One Earth Solar Farm

Draft Statement of Common Ground with West Lindsey District Council

EN010159/APP/8.4.32

~~October~~ November 2025

Figure 11.1: Site Location and Study Area

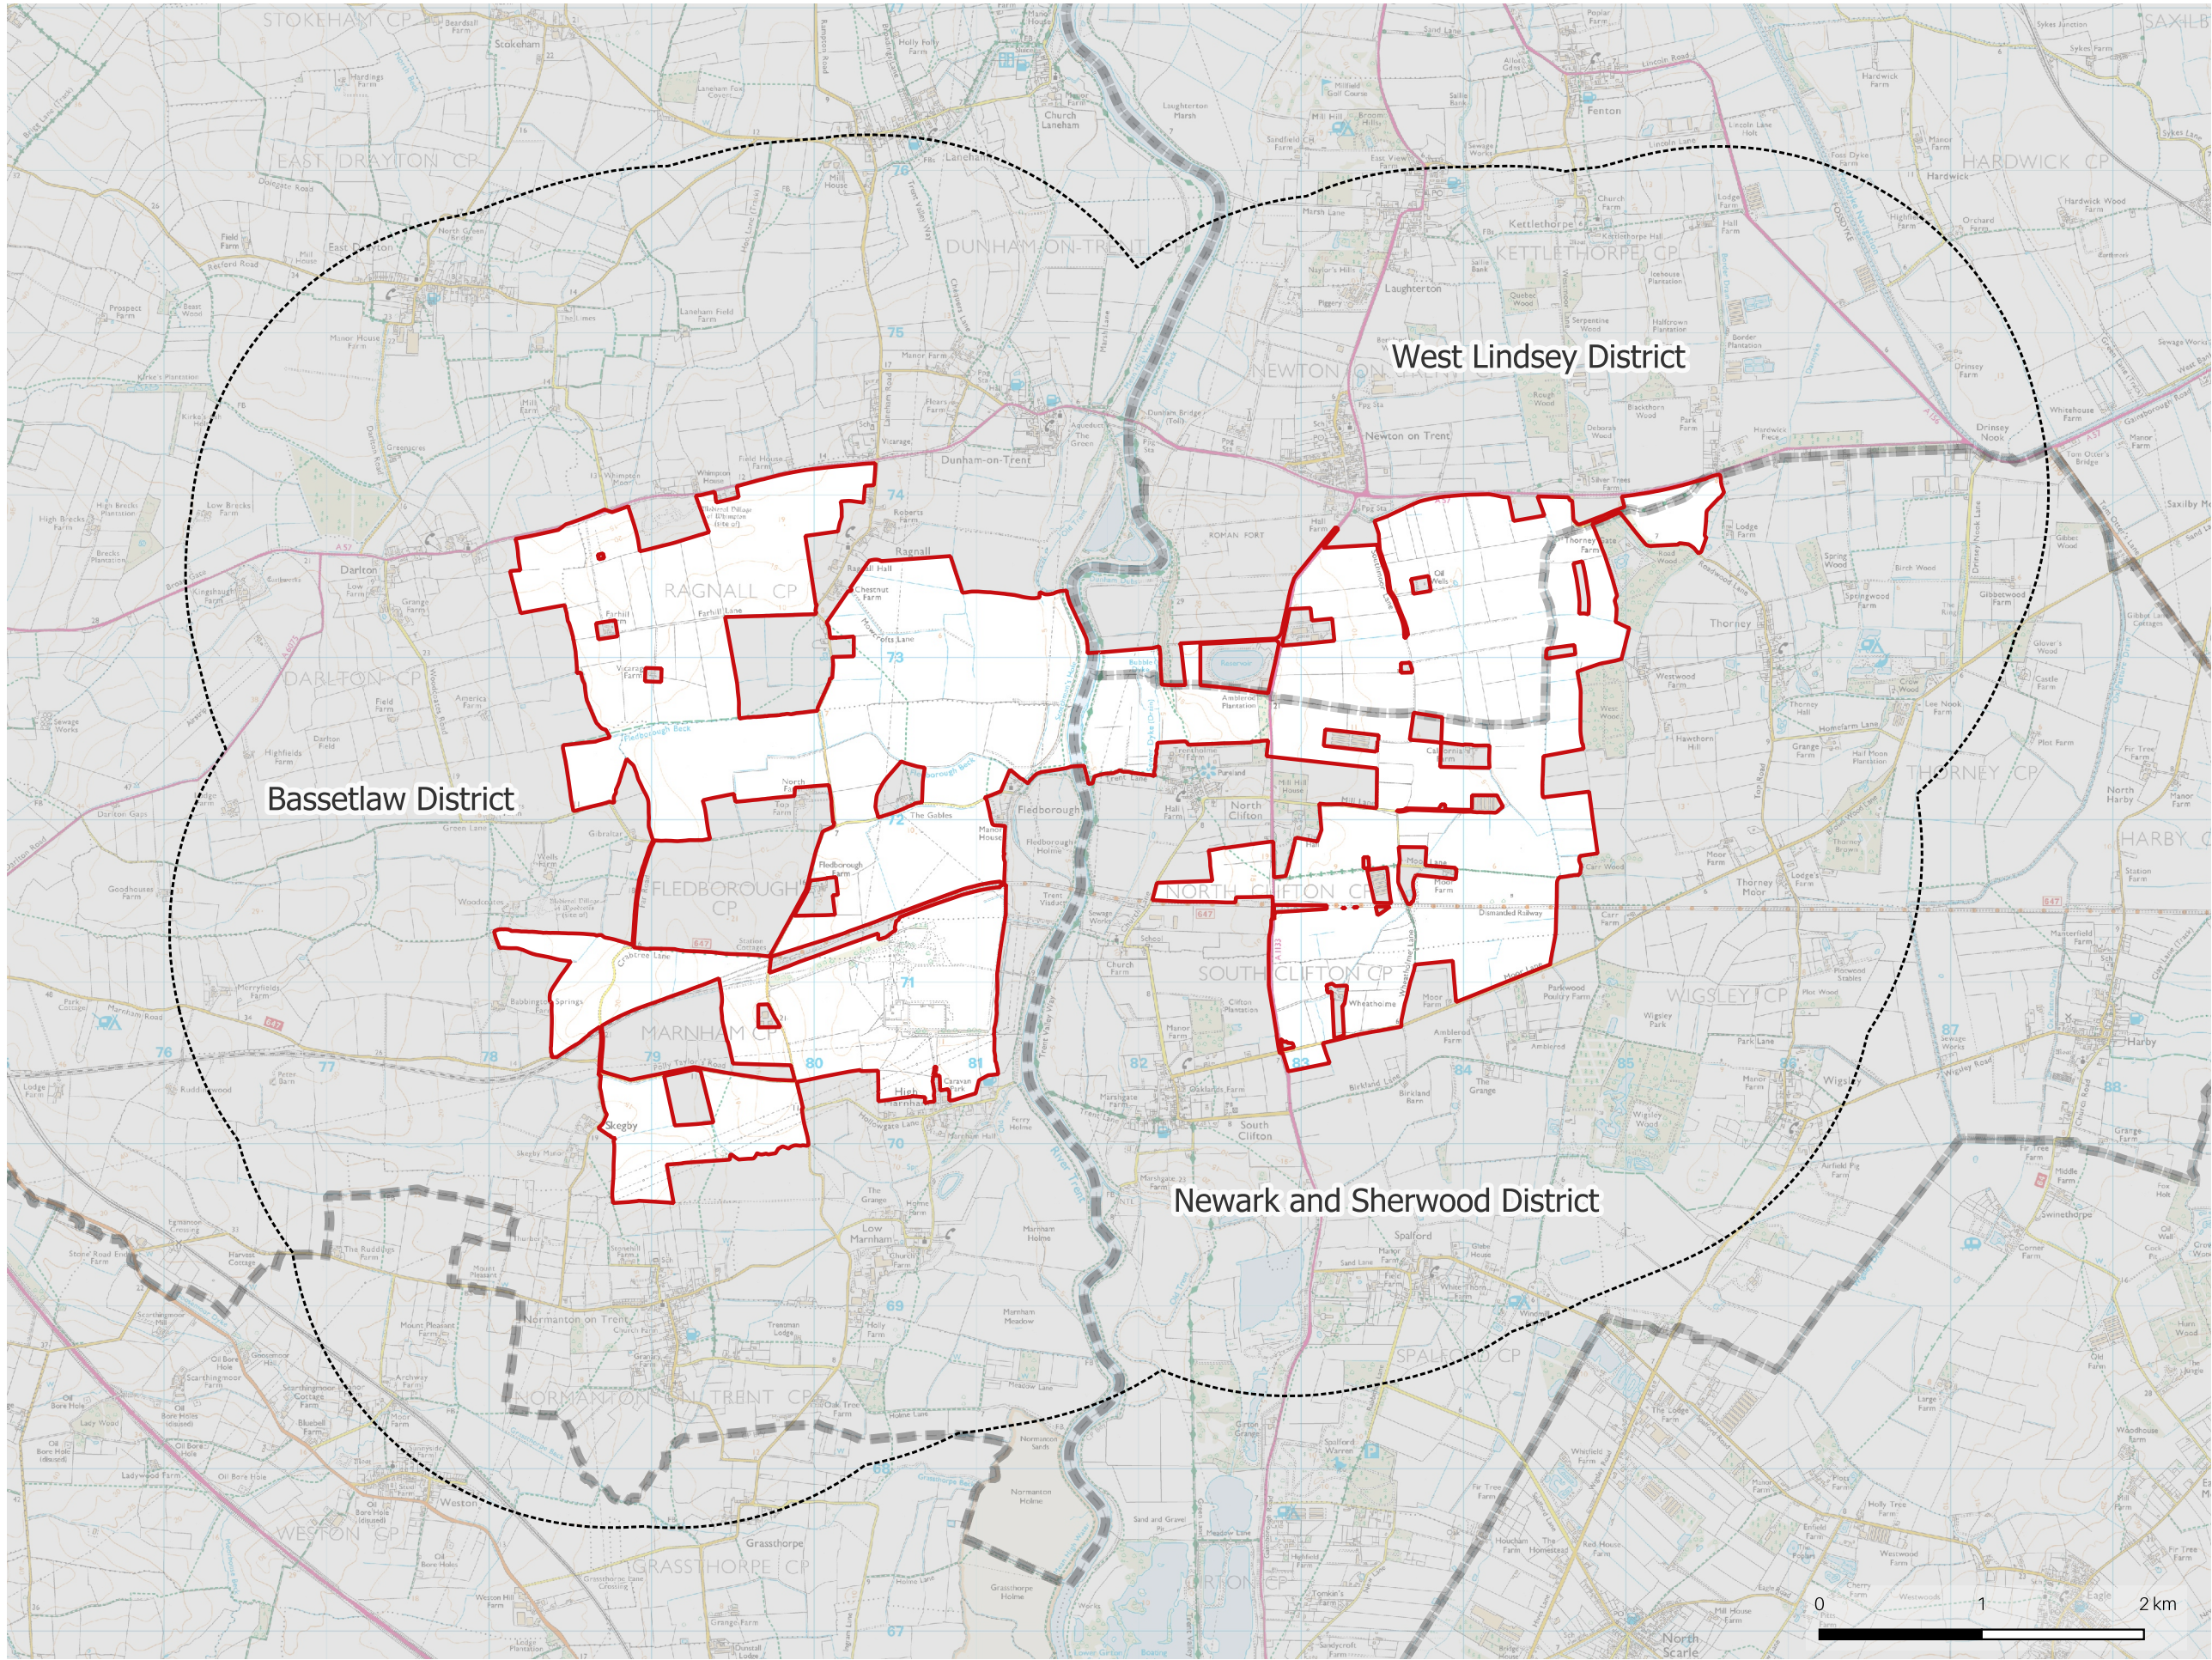
Ref.	Description of Matter	Stakeholder Comment	Applicant's Response	Status
04-01	LVIA methodology	No comments or concerns on the LVIA methodology have been raised to date.	The applicant proposes that the LVIA methodology is agreed and is considered to be in accordance with Guidelines for Landscape and Visual Impact Assessment, Third Edition, and the associated clarification note (LITGN-2024-01).	Agreed
04-02	LVIA Study Area	<p>West Lindsey District Council requested that further justification should be provided for the proposed 2km LVIA Study Area. In response, photographs from 8 locations were provided by the applicant to test the judgement of no significant visibility beyond 2km.</p> <p>West Lindsey District Council welcomed this additional information and considered the 2km Study Area to be sufficient.</p>	The LVIA 2km Study Area is agreed as being appropriate.	Agreed

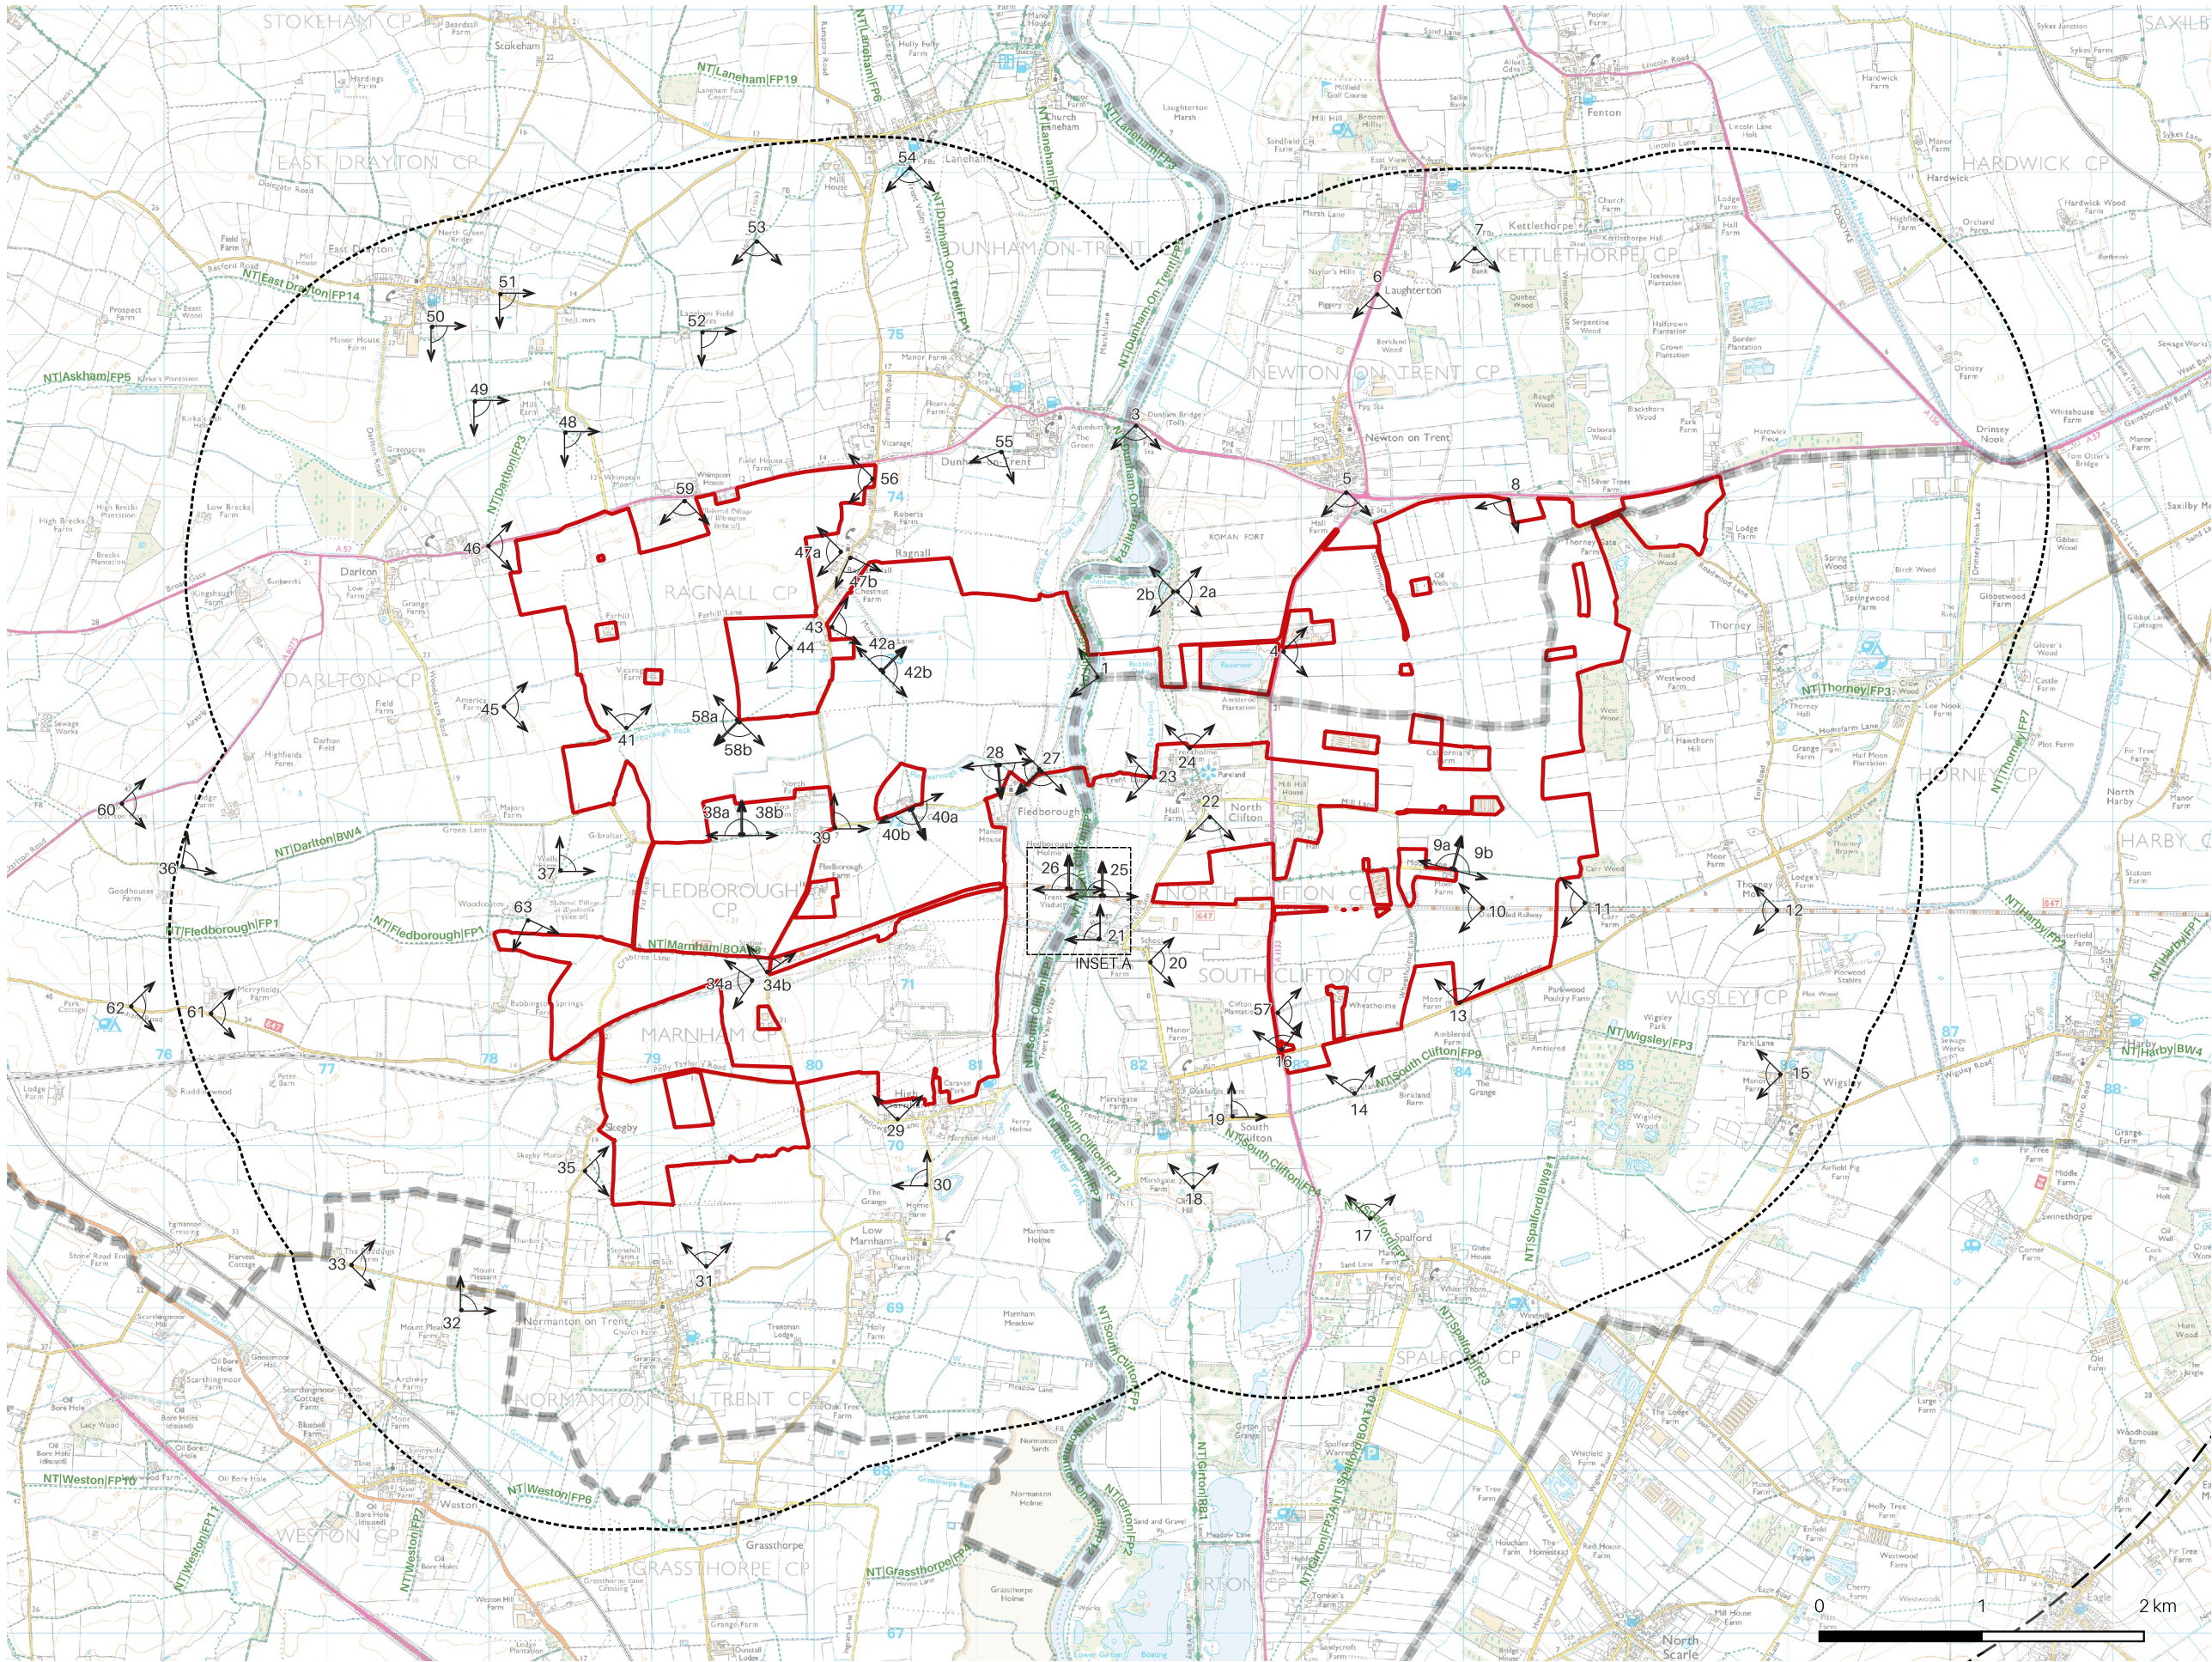
04-06	Scope of photomontages	West Lindsey District Council suggested an additional Type 4 photomontage from Viewpoint 8 along the A57 following review of the PEIR. No further comments or concerns on the scope of representative viewpoints have been raised to date.	Further discussion was had between the applicant and the District Councils during the preparation of the LVIA ES Chapter regarding the scope of photomontages resulting in agreement that any justification for the photomontage scope should be included within the LVIA. The photomontage scope is agreed.	Agreed
